From: Amanda Scholes on behalf of Planning.Responses
Sent: 10 October 2017 08:31
To: Planning Scanning
Subject: FW: FW: BE/71/17/PL - Wickes, Bognor Drainage Scheme

Final drainage comments

Our responses to Paul Cann of Arun Council are as follows:

| <b>15-112 / 500</b> | <b>P3</b> |

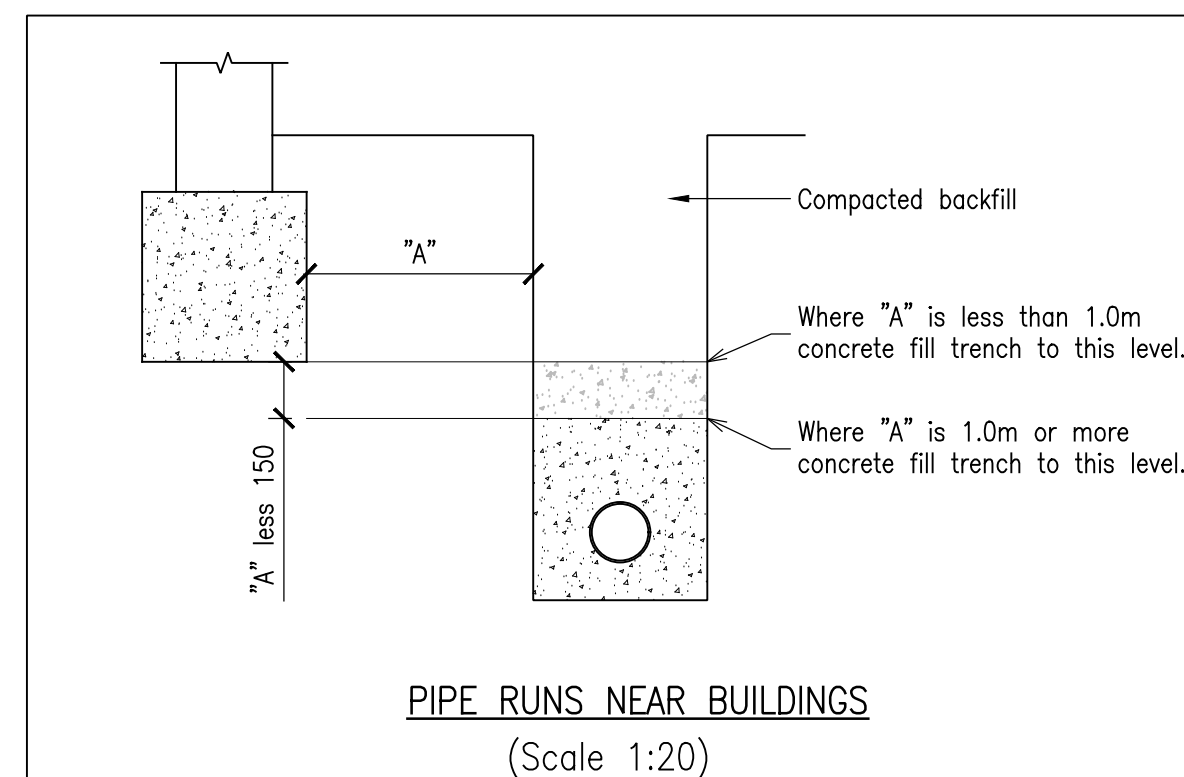
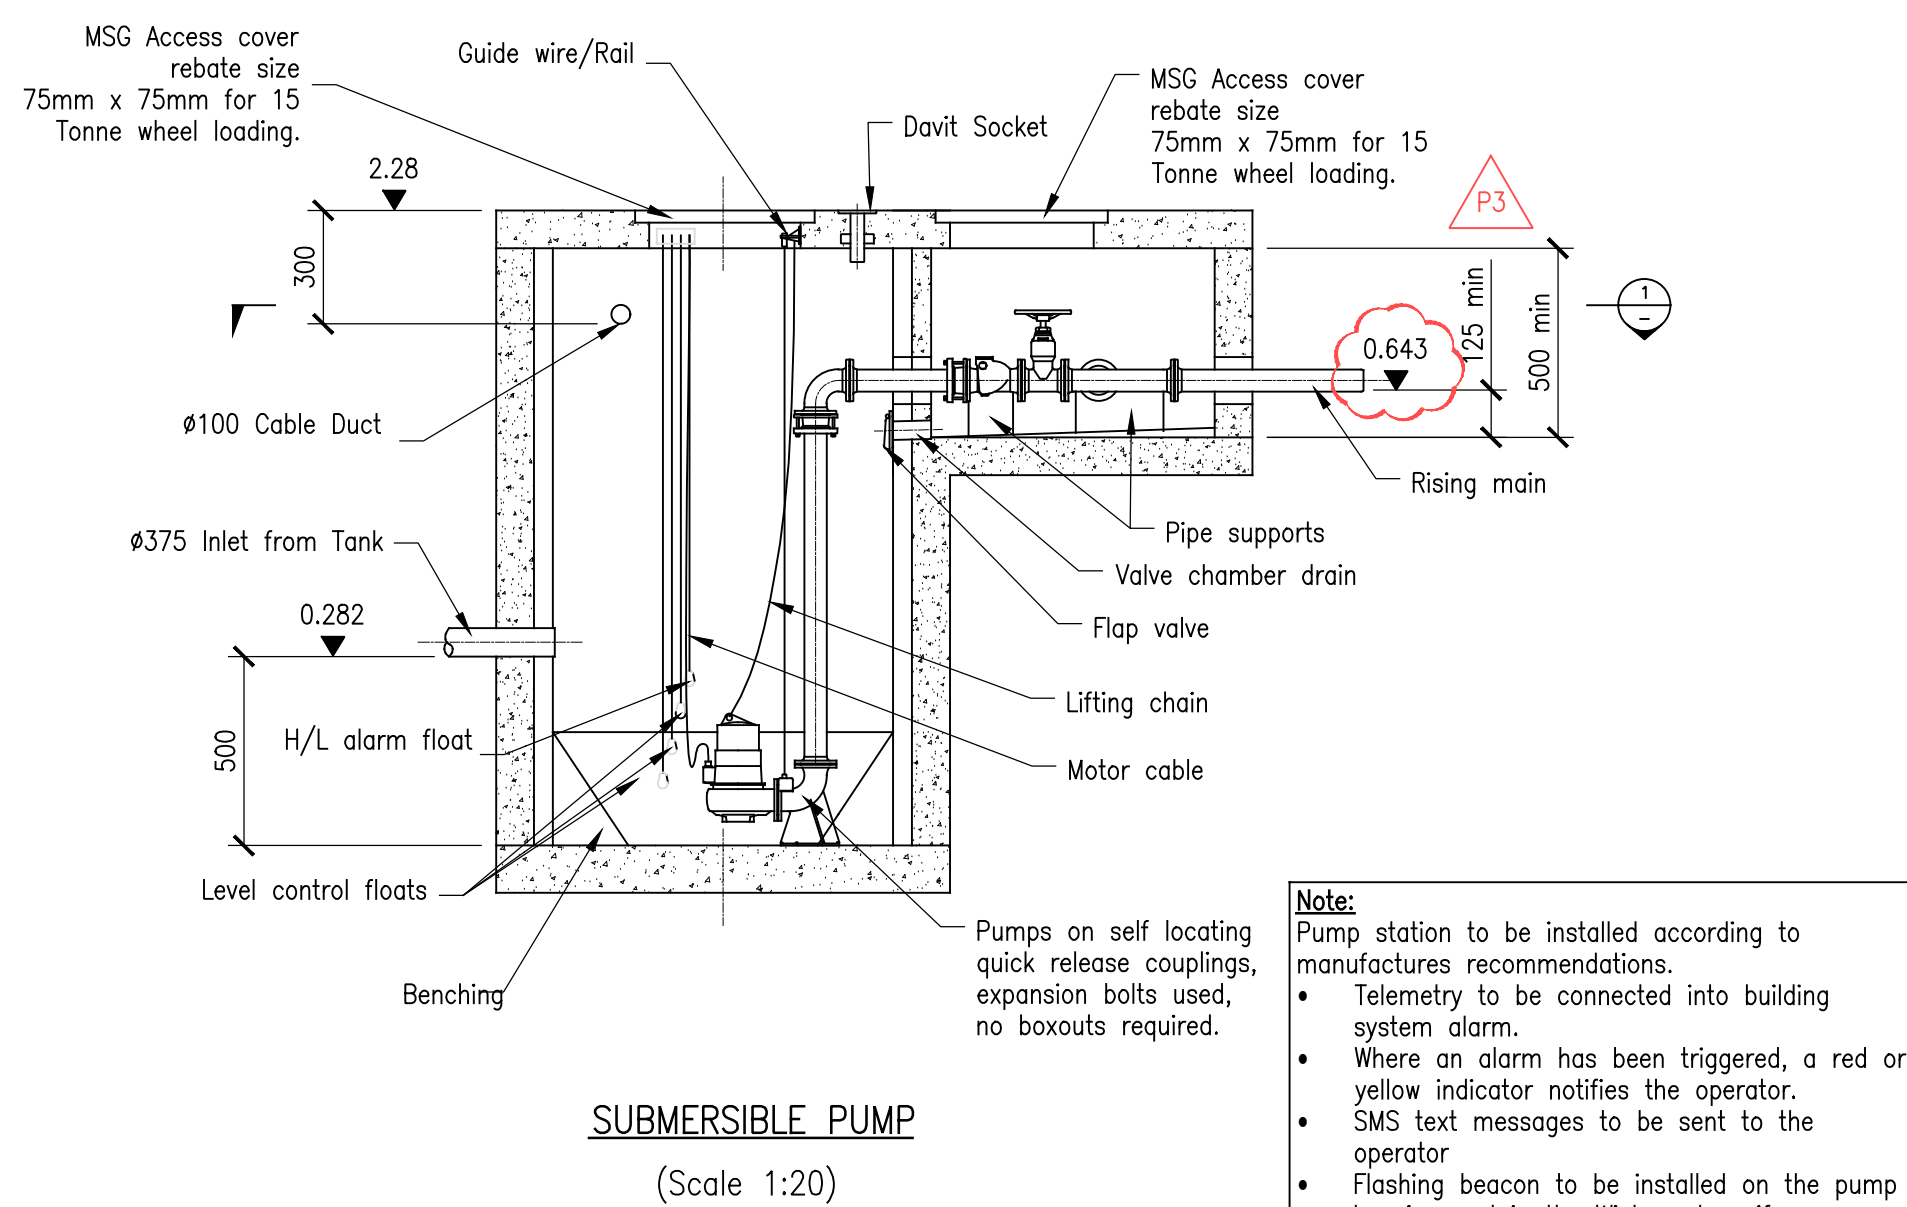
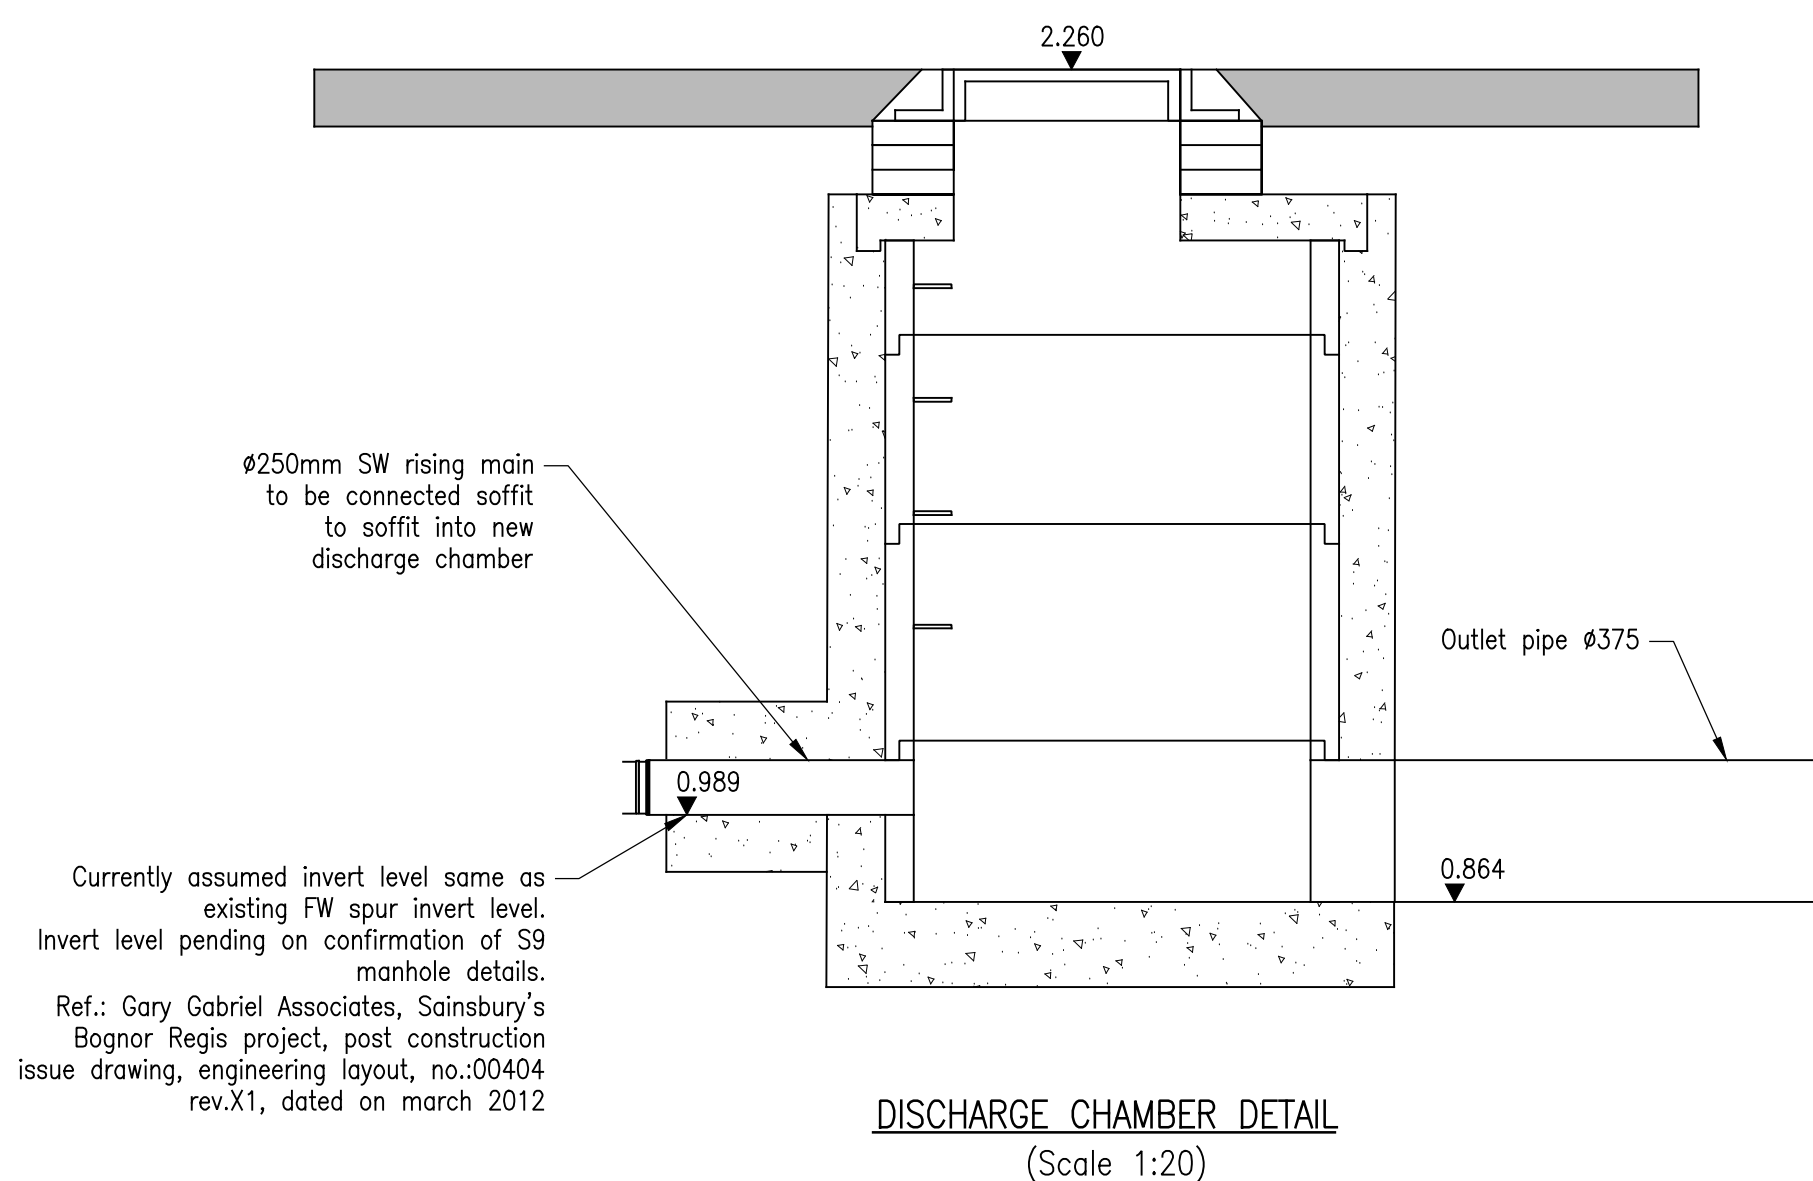
3. The construction detail for the discharge chamber refers to existing manhole S9 and a 450mm outlet pipe. This is not the case. It should show a 250mm diameter rising main with a 375mm diameter outlet. There are some spelling errors too.

Amended to illustrate correct diameters as attached 500P3

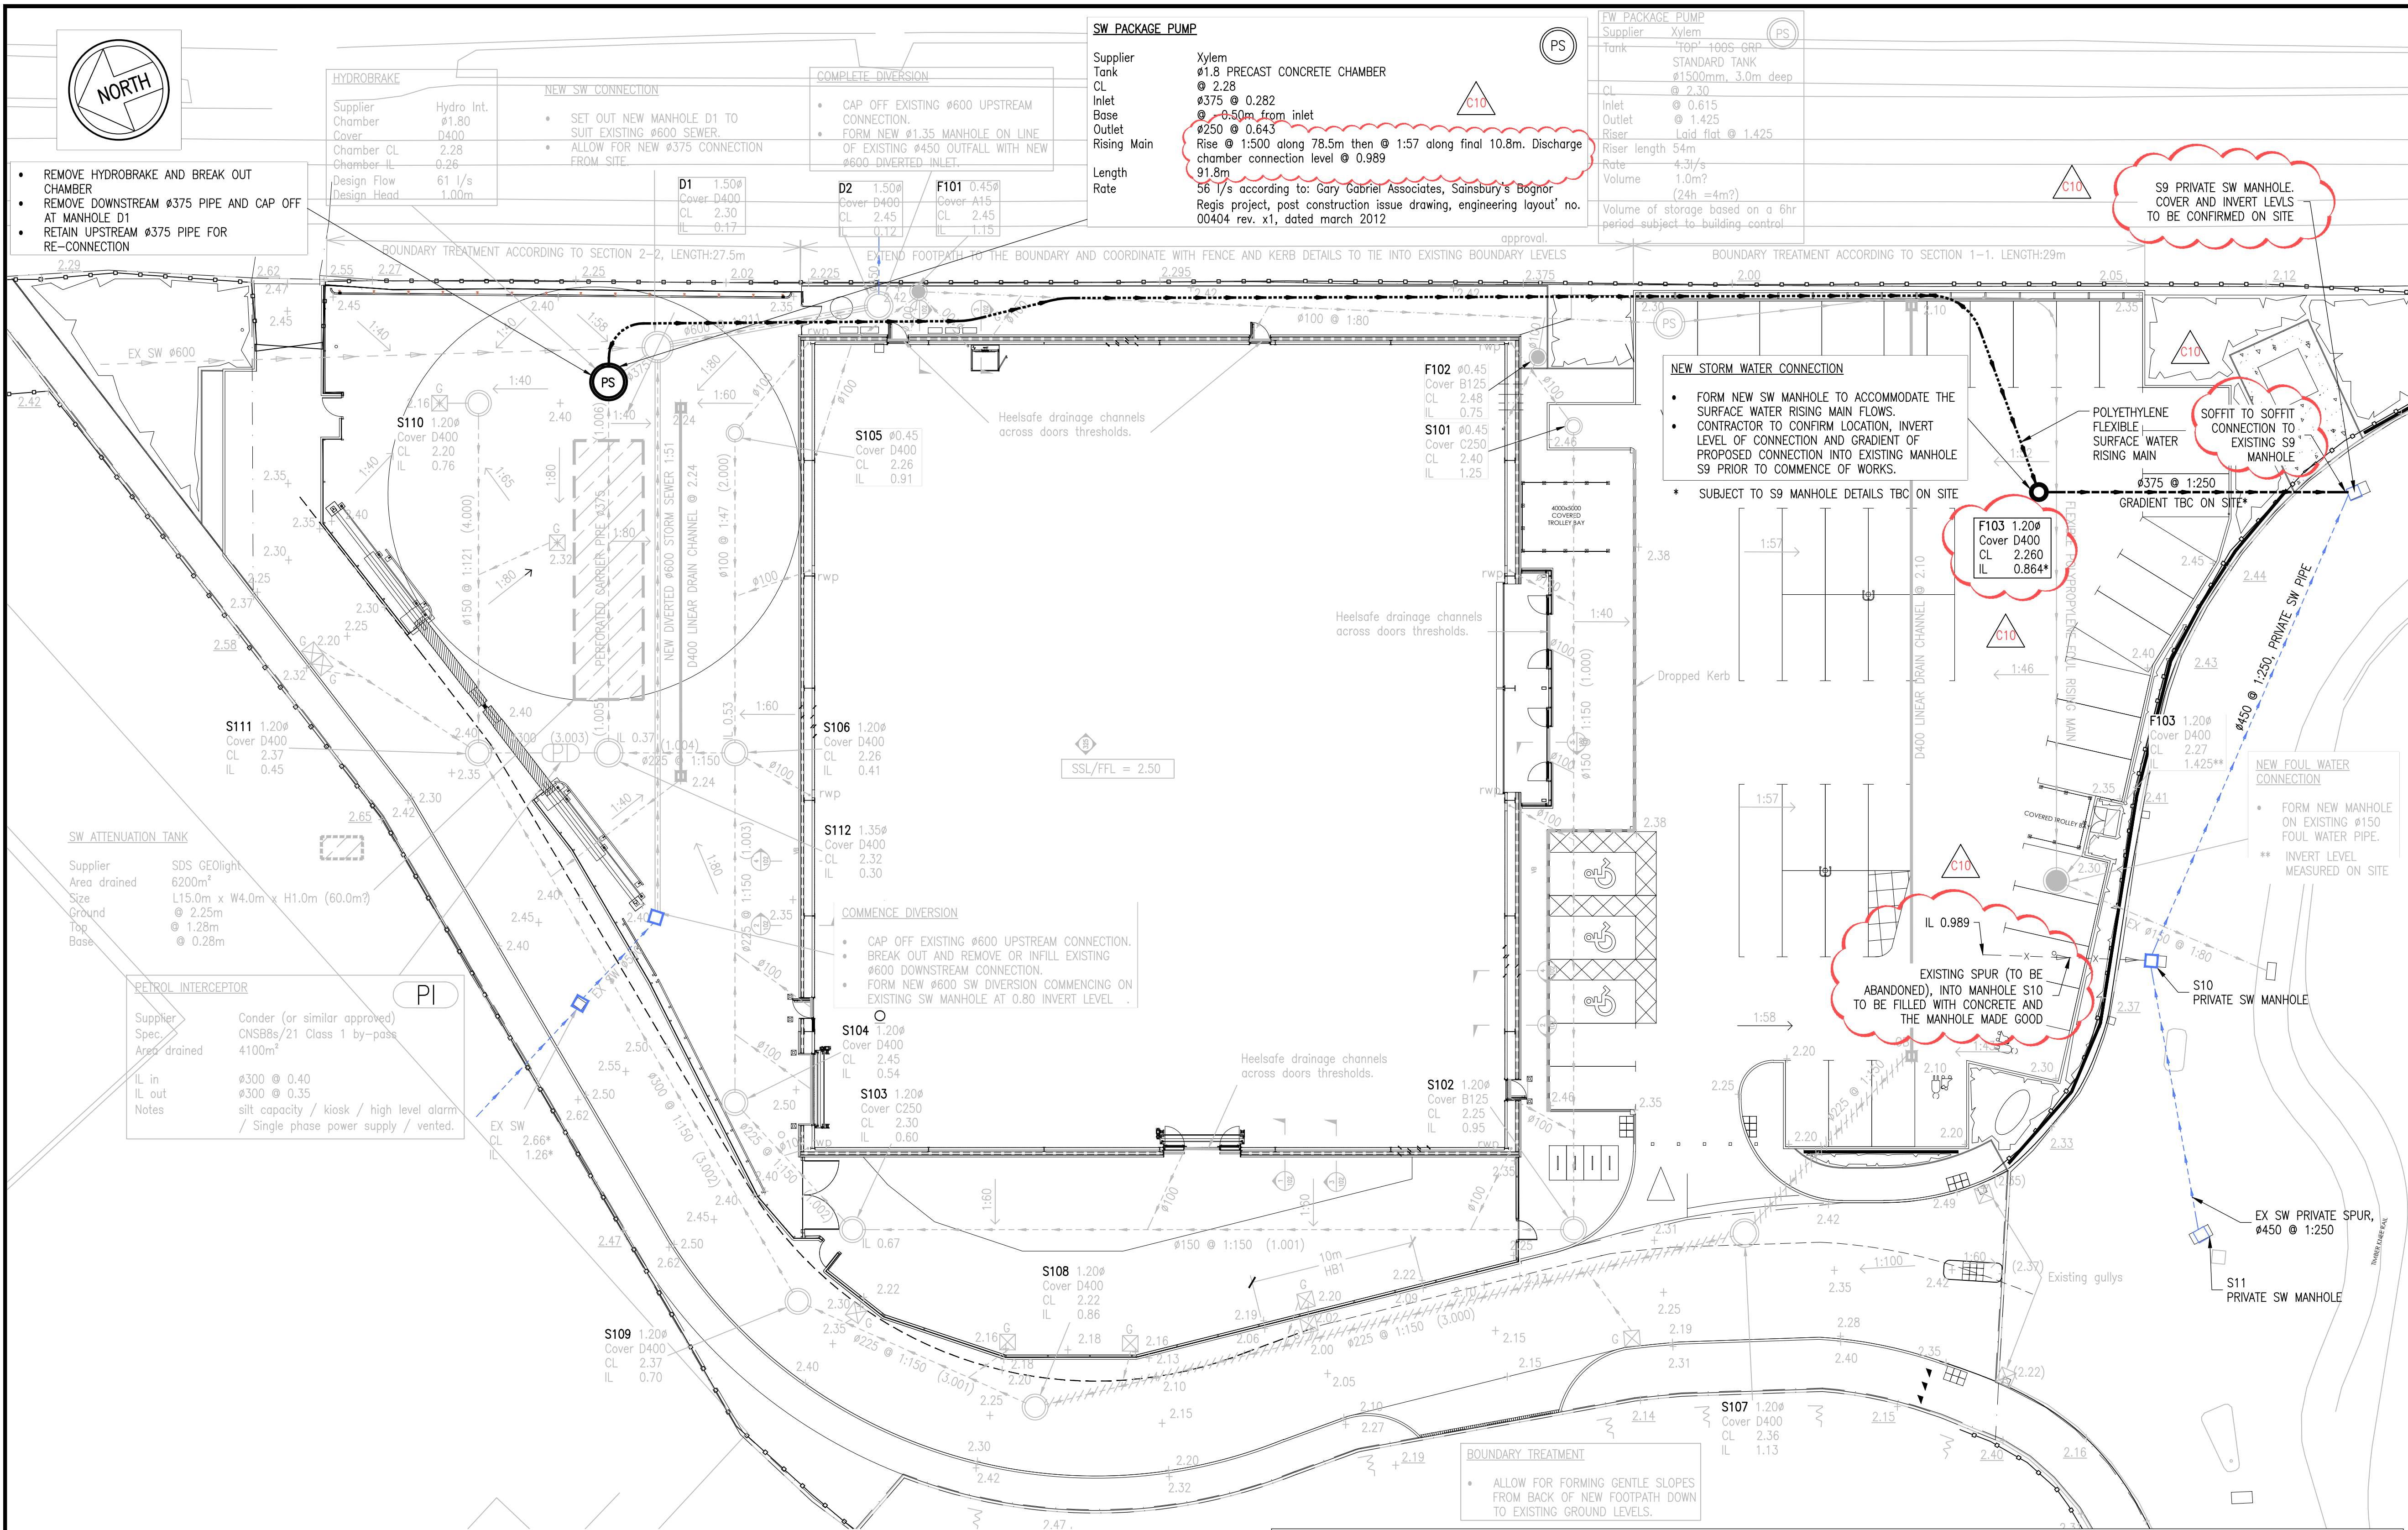
1. Connection to manhole S9 to be made at soffit to soffit level. Specify connection invert level/invert level of existing 450mm pipe.

2. Specify invert levels in discharge chamber. Ie. 0.989 if intending to lay it flat, as per notes? A gradual rise would be preferred though.

4. Improve angle of discharge of the rising main into the discharge chamber ie. not 90 degrees.

5. Existing spur (to be abandoned) into manhole S10 to be filled with concrete and the manhole made good. Add note.

The invert level of existing chamber S9 is unknown and subject to an on-site measurement. Once known any alterations to the upstream design shall be carried out to suit, including a soffit to soffit connection.

Amended to illustrate a gradual rise as attached 300C10

Amended as attached 300C10

Amended as attached 300C10
